62 Ferringham Lane, Ferring – Your ref. FG/123/12

The above property runs along our western boundary and we wish to object to the above application.

DRAWING No.
Drawing 2

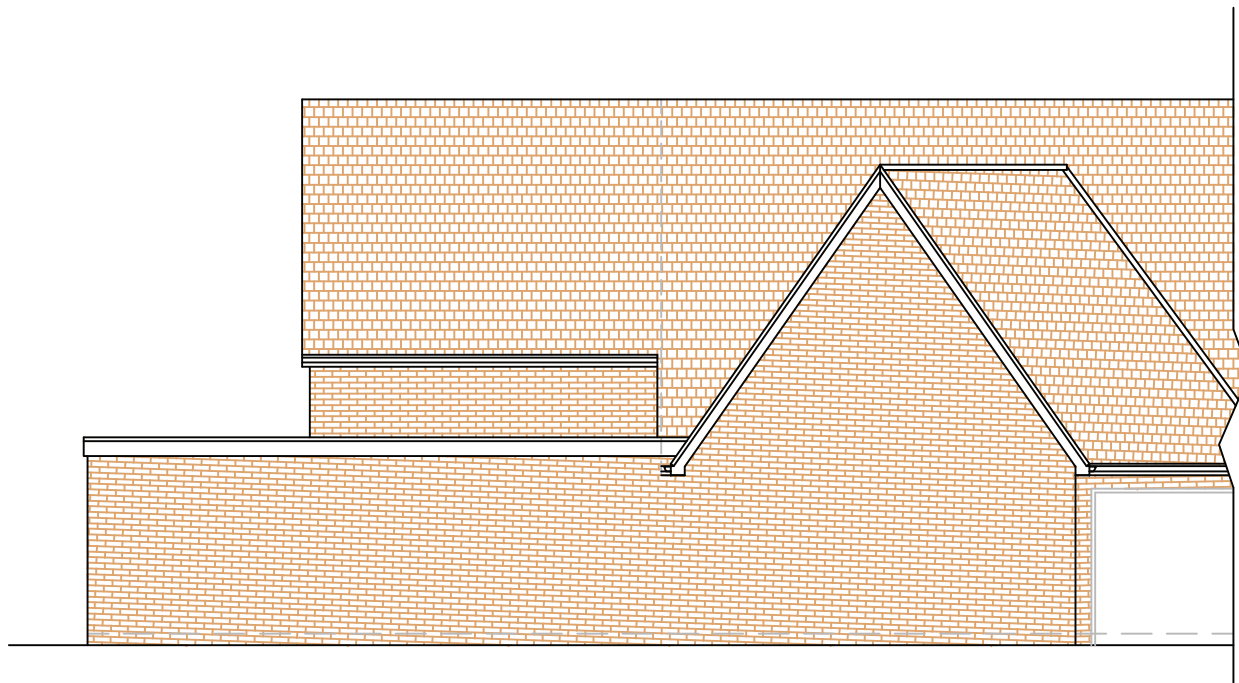
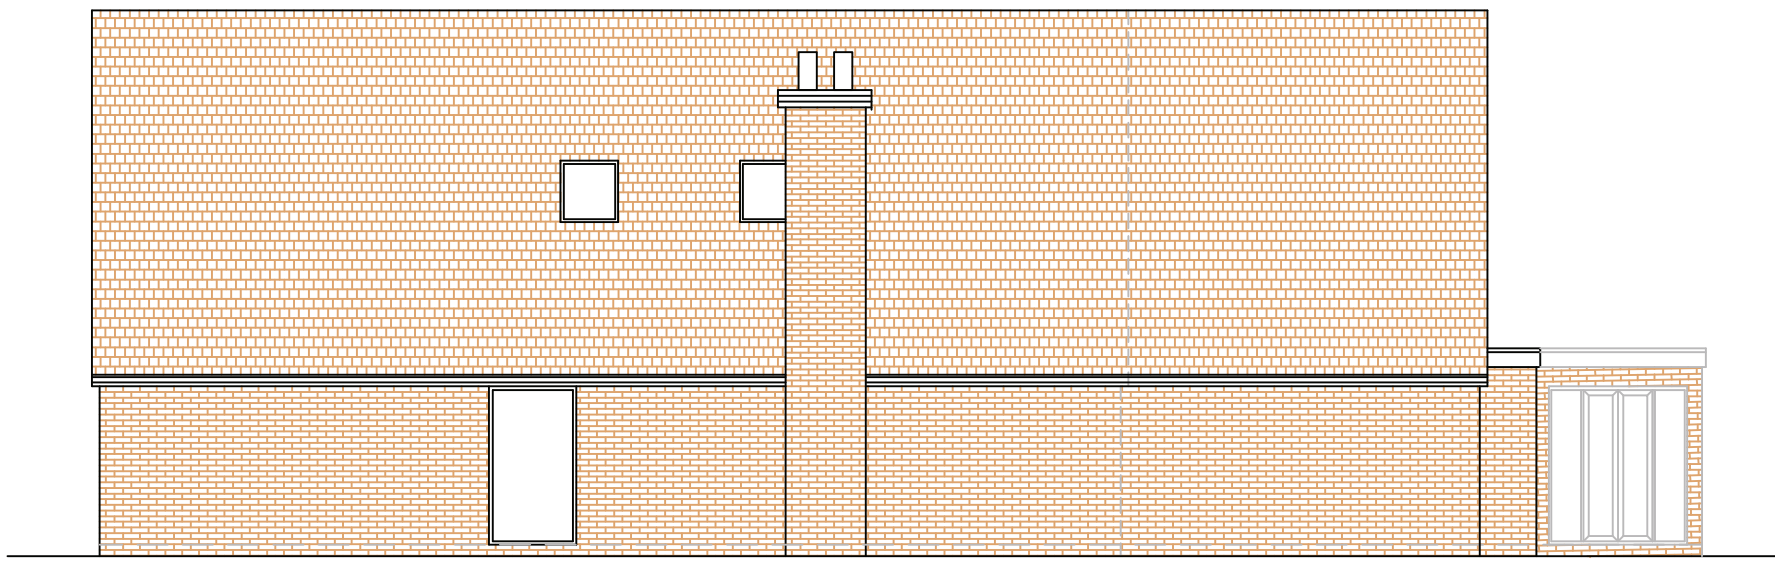
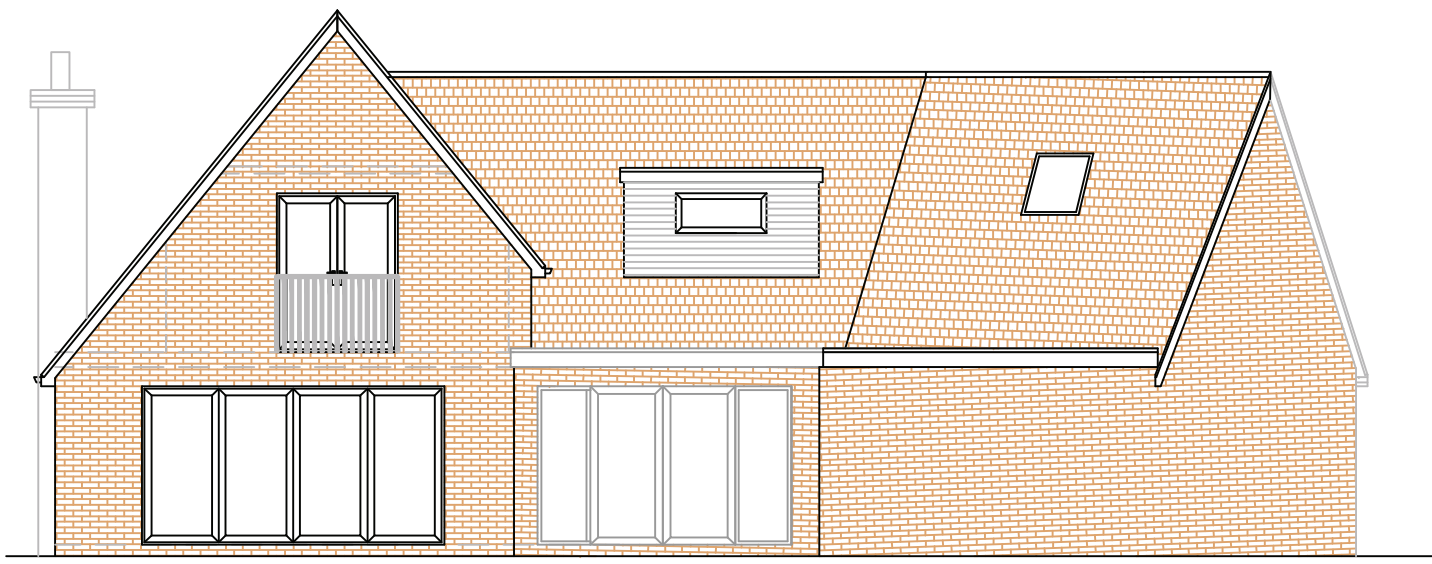
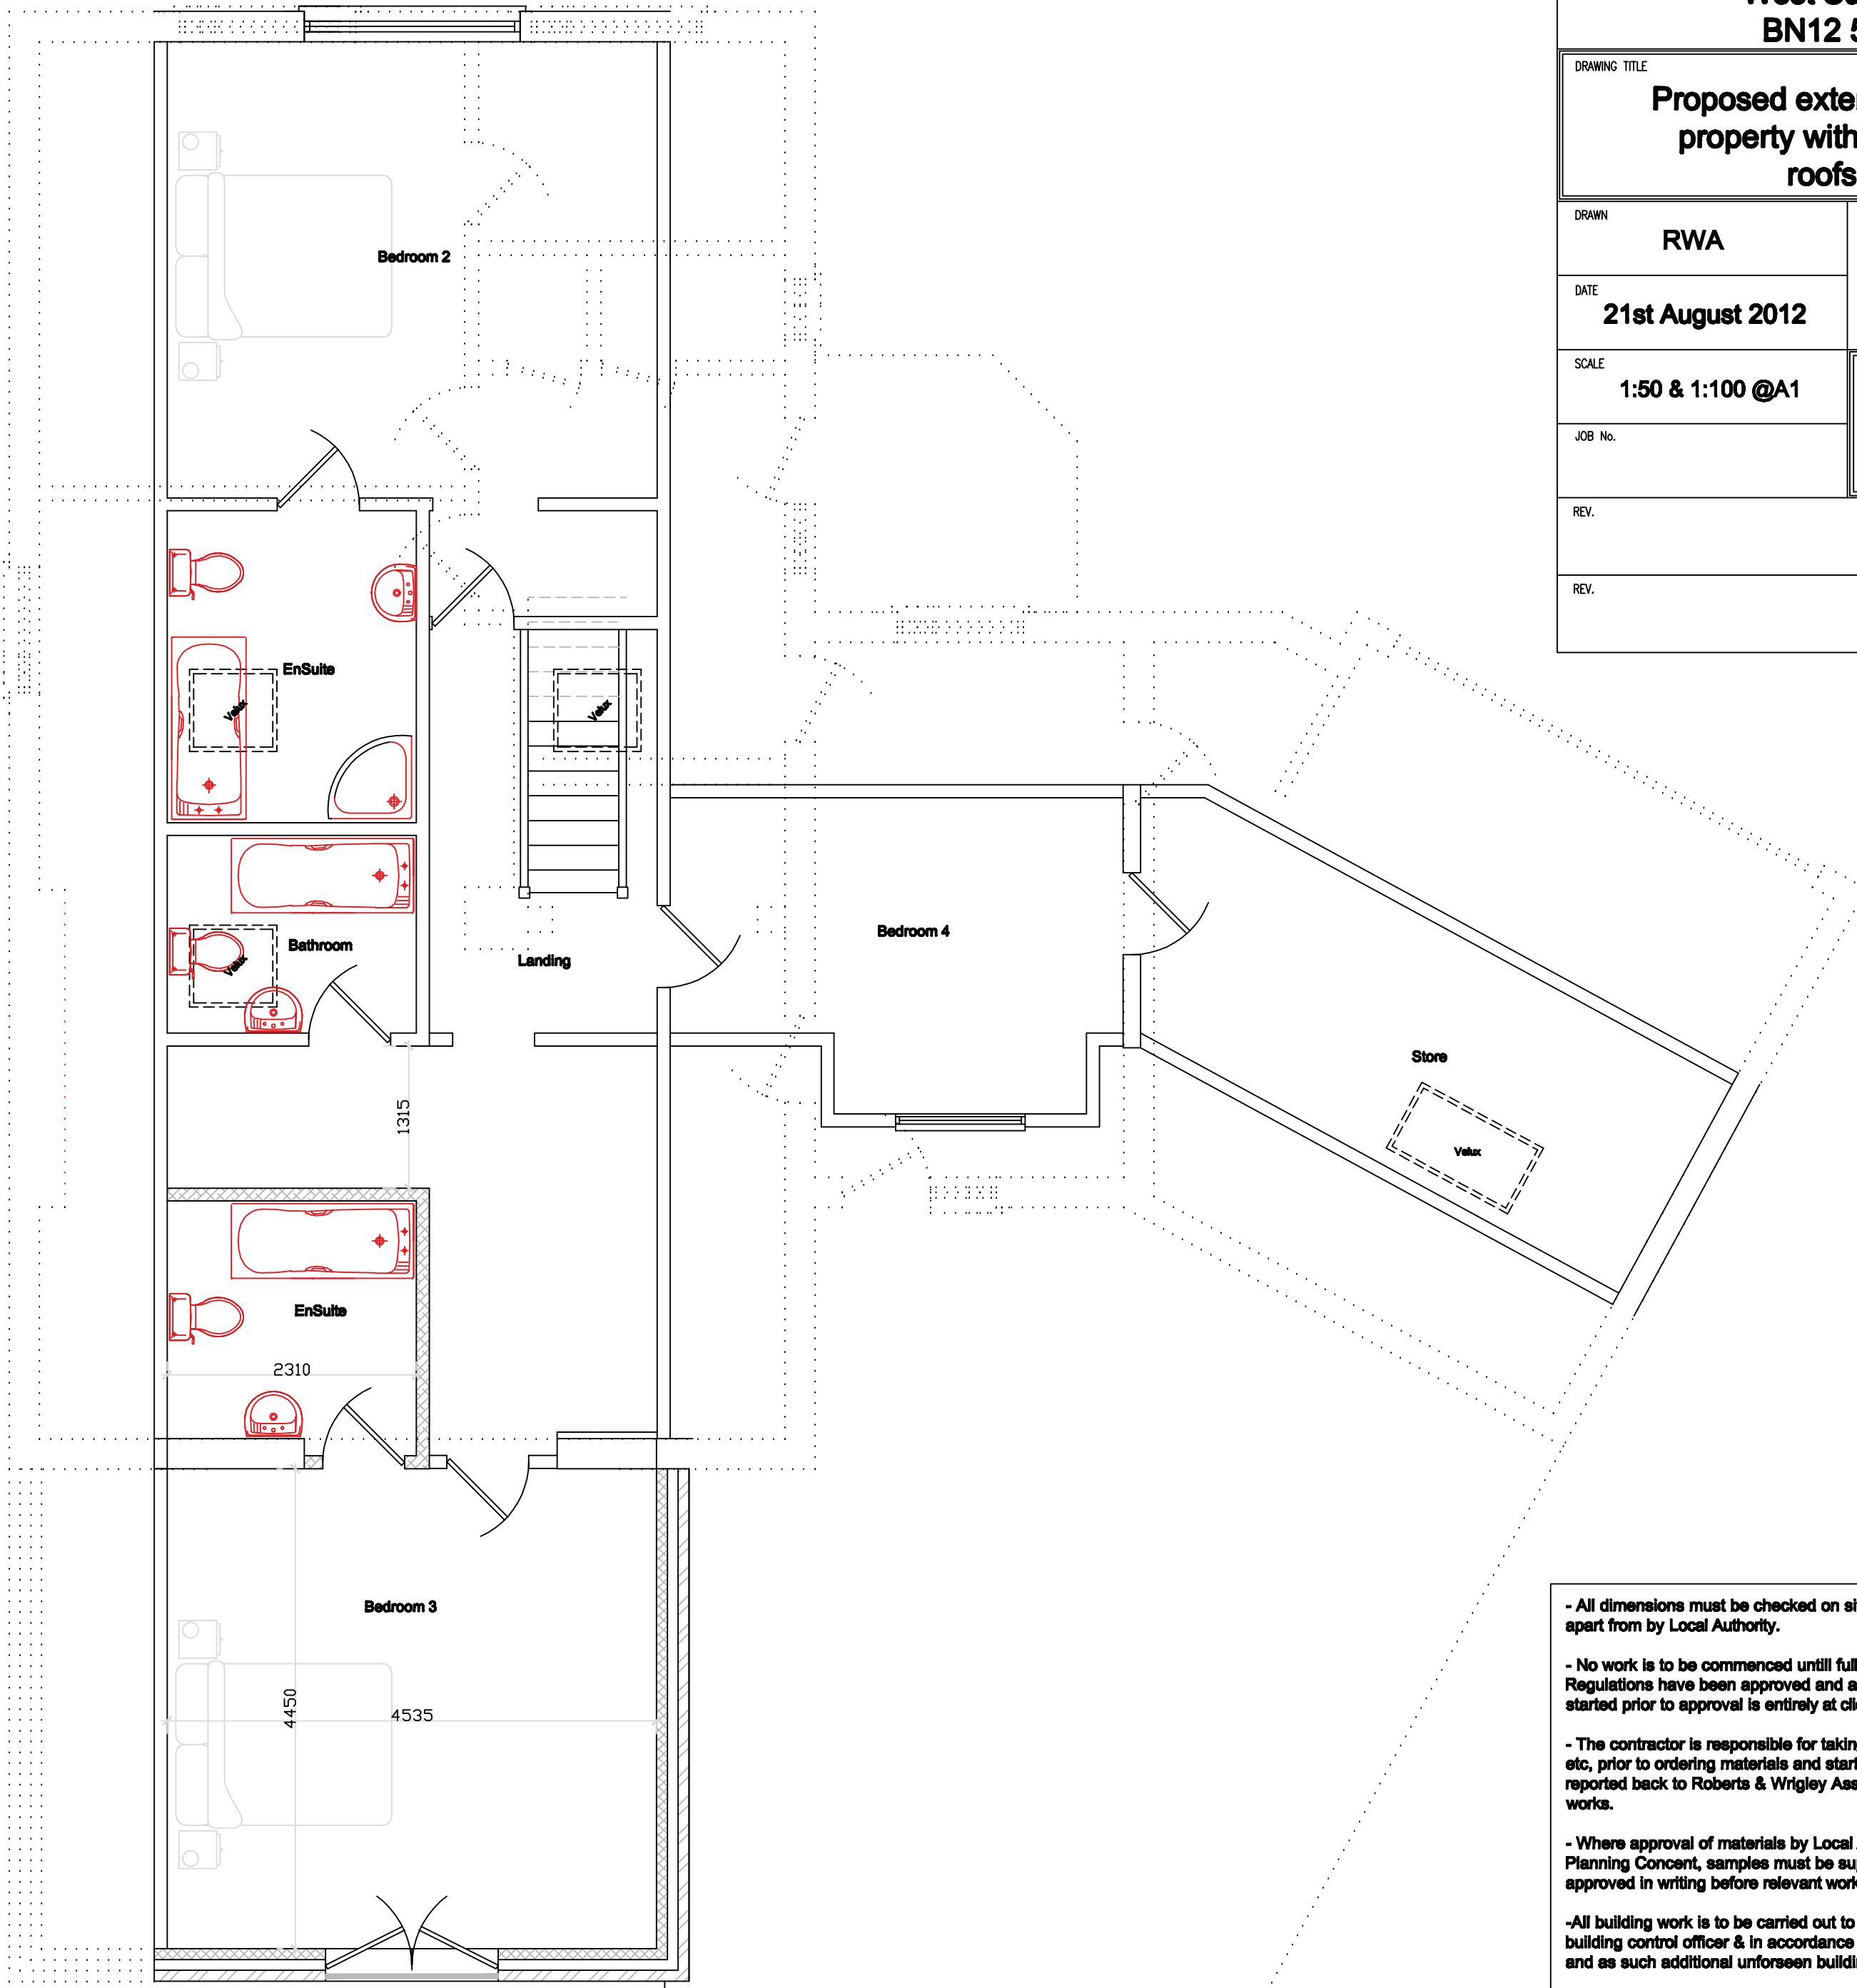
The "flat" roof (mentioned in the Planning Application Report on the original application ref. FG/13/12) according to our estimates now slopes from a height of about 3.3m on the eastern side of the two-storey extension to 2.9m on the eastern side of the single storey extension. However the parapet on the southern end of the single storey is at an estimated height of 3.6m and falls to about 3.3m.

The alteration of the end of the single storey extension results in the south facing wall including windows being angled towards our boundary which makes the parapet more overpowering.

We strongly object to the changes the subject of this application on the grounds that the southern parapet of the single storey extension is unsightly and too high. We consider that it has been built to a height that is quite unnecessary in relation to the roof (see enclosed photos).
